THE SOD GUY - SALES LOT

SITE DEVELOPMENT PLANS
LOT 1, APPALOOSA HIGHWAY 24 SUBDIVISION

THE SOD GUY - SALES LOT
SITE PLAN

Sign Plan_v1-redline.pdf Markup Summary

LOT 1, APPALOOSA HWY 24
SUBDIVISION

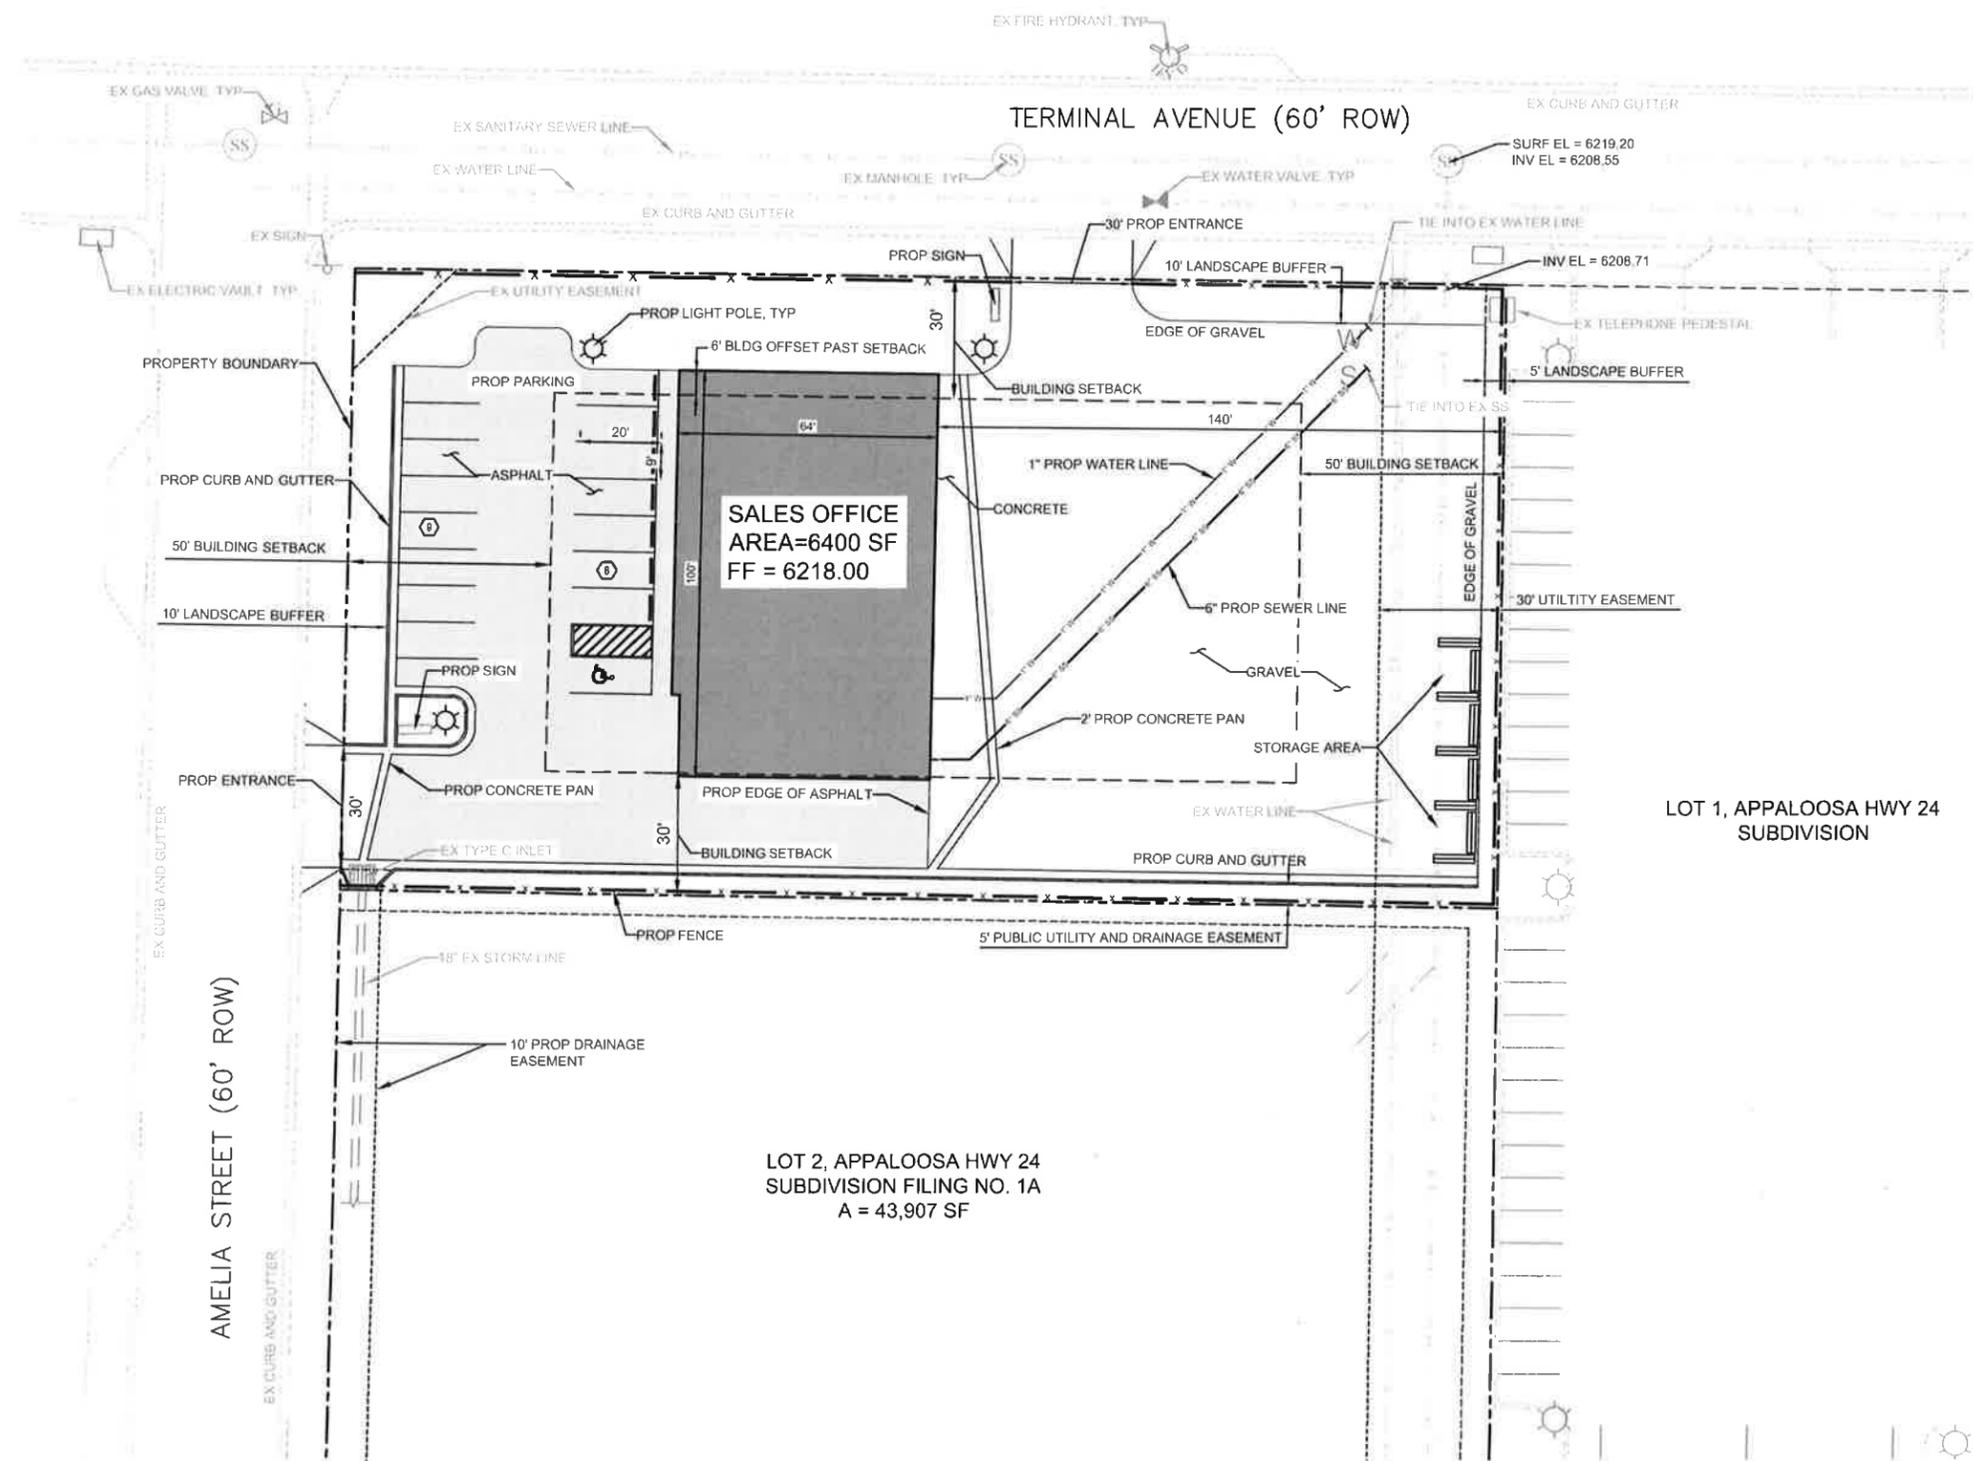
See Freestanding sign standards in Chapter 6 of the Land Development Code. A separate Sign Plan application will be necessary.

Only one freestanding sign is allowed.

Show sign setback (no closer than 3 feet is allowed)
